Current Zoning: MUDD-O SPA (mixed-use development district, optional, site plan amendment)
Proposed Zoning: MUDD-O SPA (mixed-use development district, optional, site plan amendment)

Approximately 36 acres located on the west side of Providence Road, north of Fairview Road, and west of Columbine Circle.

The petition proposes to combine four apartment buildings into two buildings without an increase the number of dwelling units. The site is currently developed with two new structure-parked apartment buildings and 17 garden-style apartment buildings dating from the 1960s.

Staff recommends approval of this petition.

RZ-100

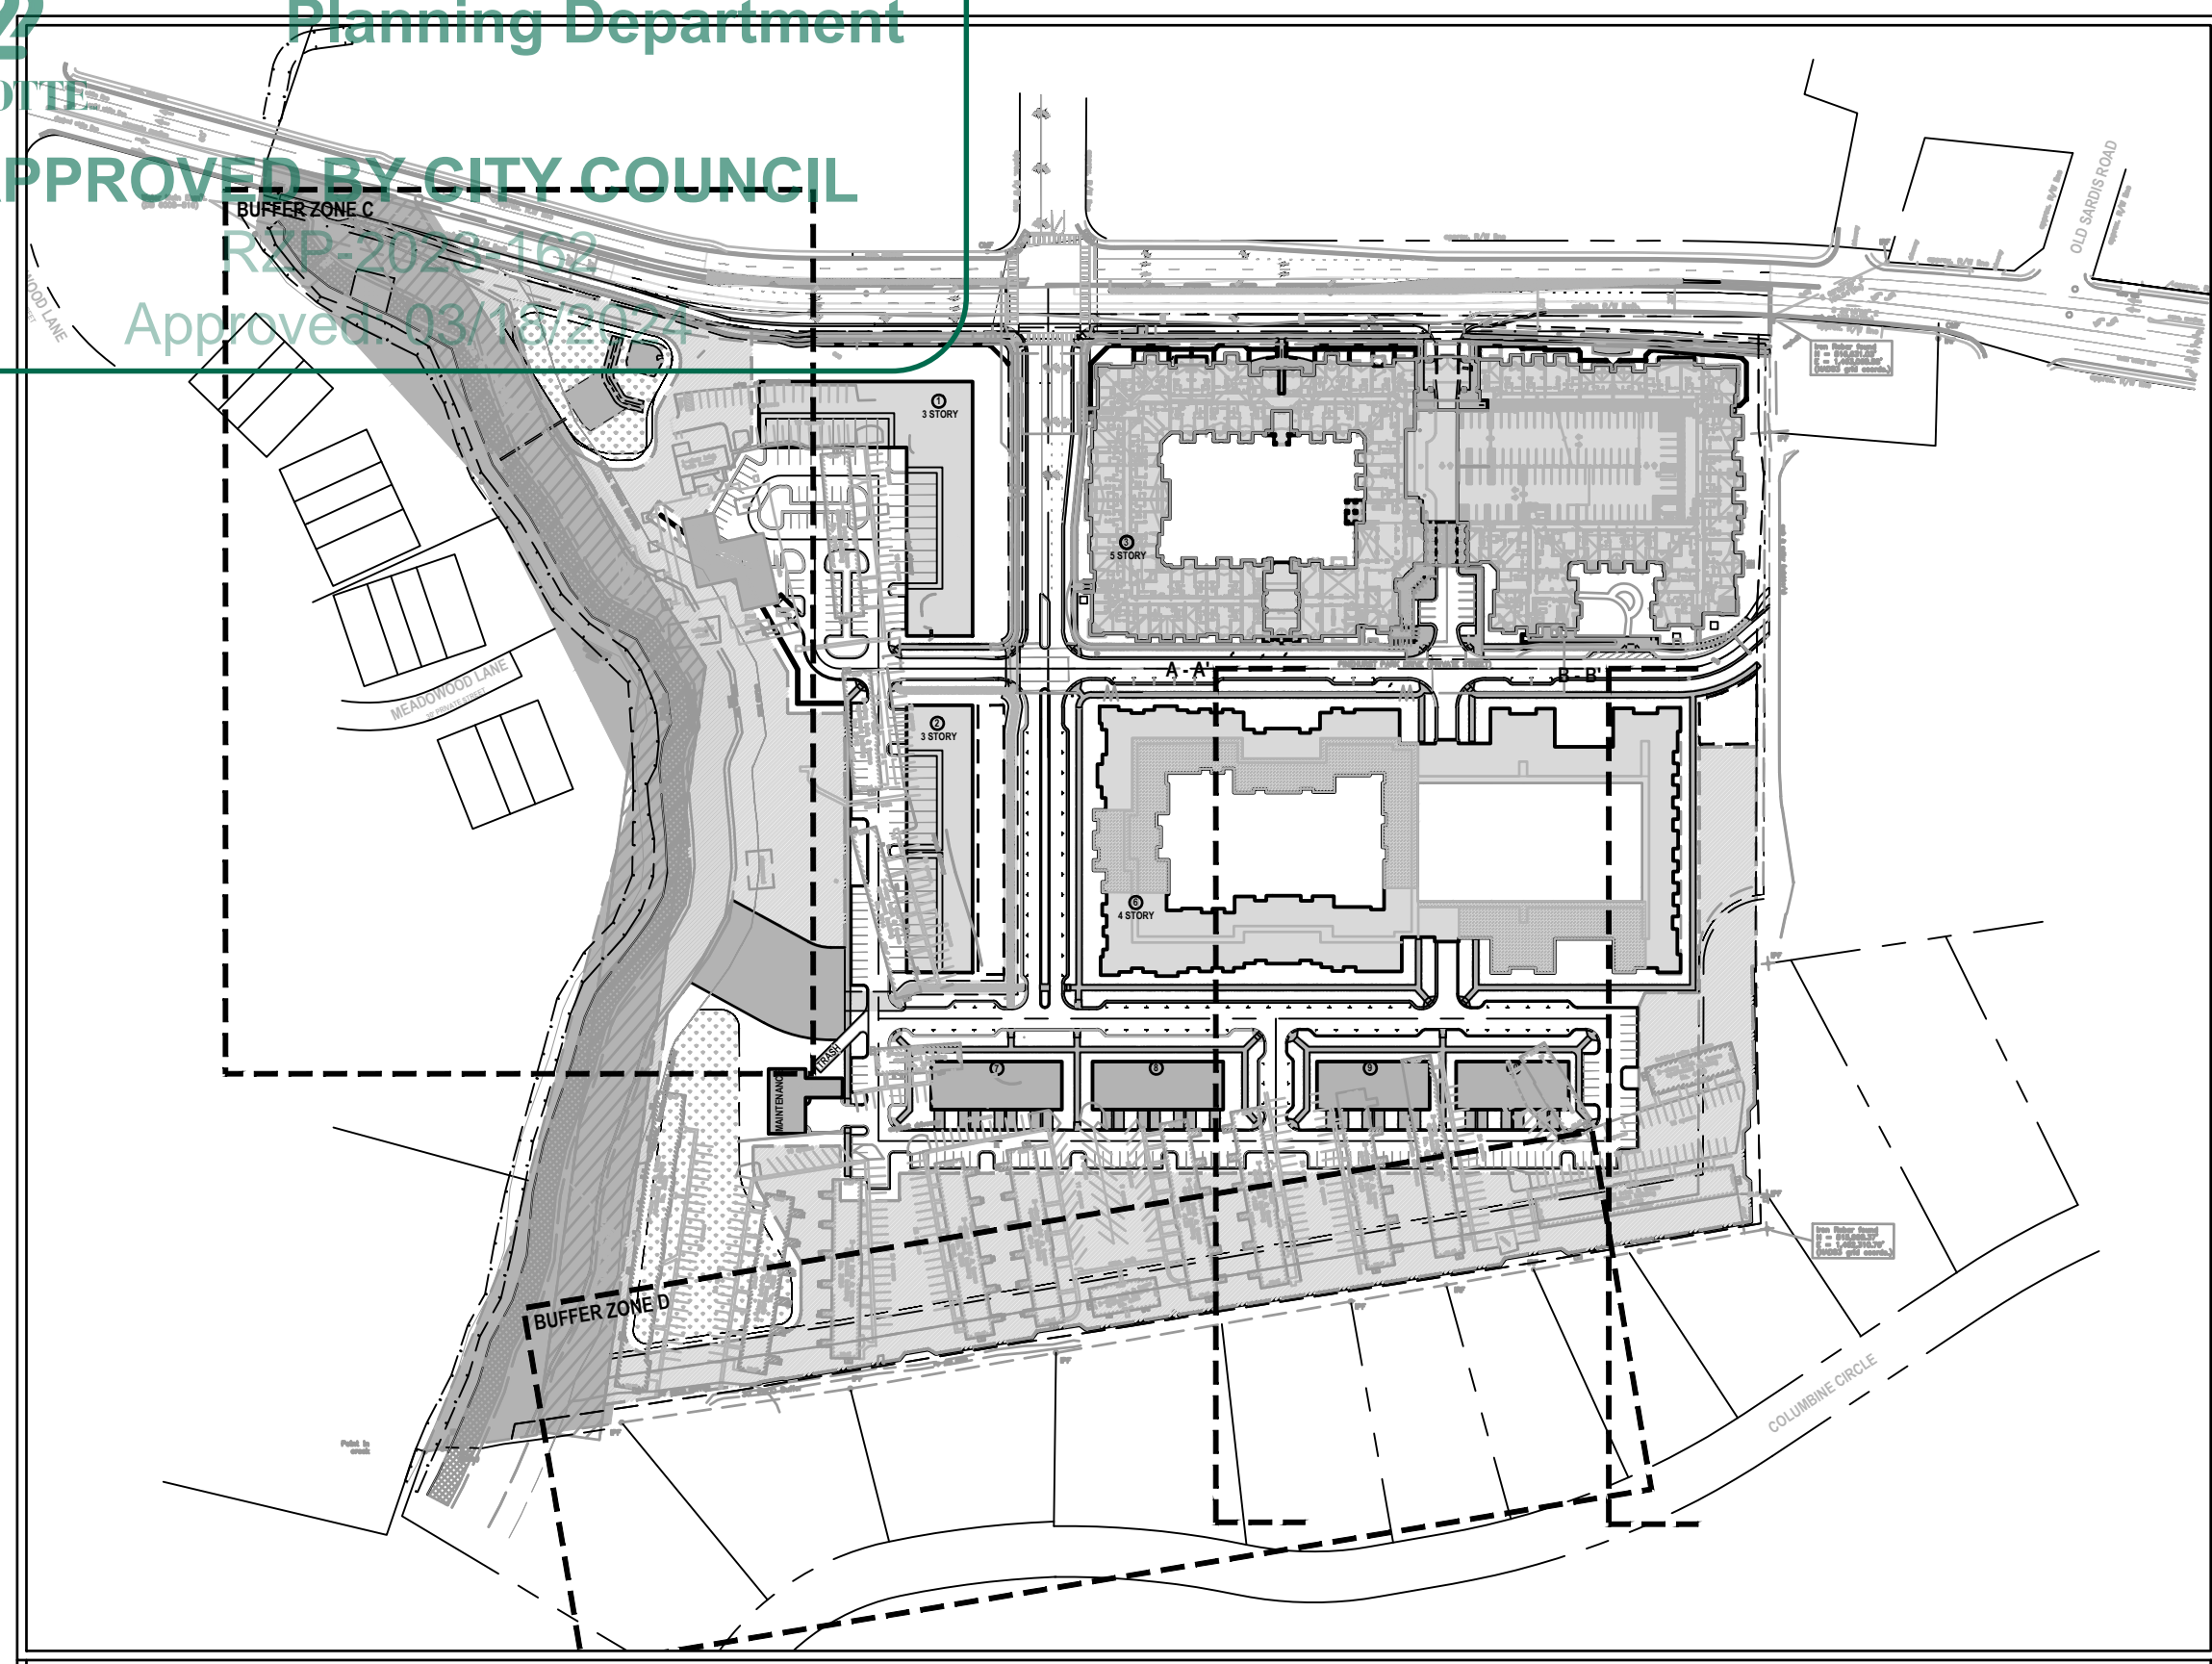
- ~~1.—Mecklenburg County Park and Rec: The proposed greenway access easement must connect to the public street ROW to provide Mecklenburg County access to the greenway dedication area. This easement shall overlap with the private street between the public street ROW and the greenway area.~~ **Addressed**

- ~~2.—Mecklenburg County Park and Rec: To clarify the previous note, Mecklenburg County requests a vehicular access easement from Providence Road to the 100' Greenway Easement along the private development streets.~~ **Addressed**

- ~~4.—Stormwater Services Land Development: Update label to say "100' SWIM and Post Construction Buffer." Buffer should be shown as extending 100' from top of bank.~~ **Addressed**

-
5. ~~Stormwater Services Land Development: add to note 8.d. under Environmental Features: "and mitigated if required by City ordinance."~~ **Addressed**
 6. ~~Urban Forestry: Recommend changing the tree save conditional language. Based on what options are being used, tree save may be greater than 15%.~~ **Addressed**
 7. ~~Urban Forestry: Tree save must meet min size requirements. Some of what is shown would not qualify between the maintenance building and the water quality #2.~~ **Addressed**
 8. ~~Urban Forestry: While allowed, the amenity area within tree save would need to be accounted for at 150%.~~ **Addressed**
-
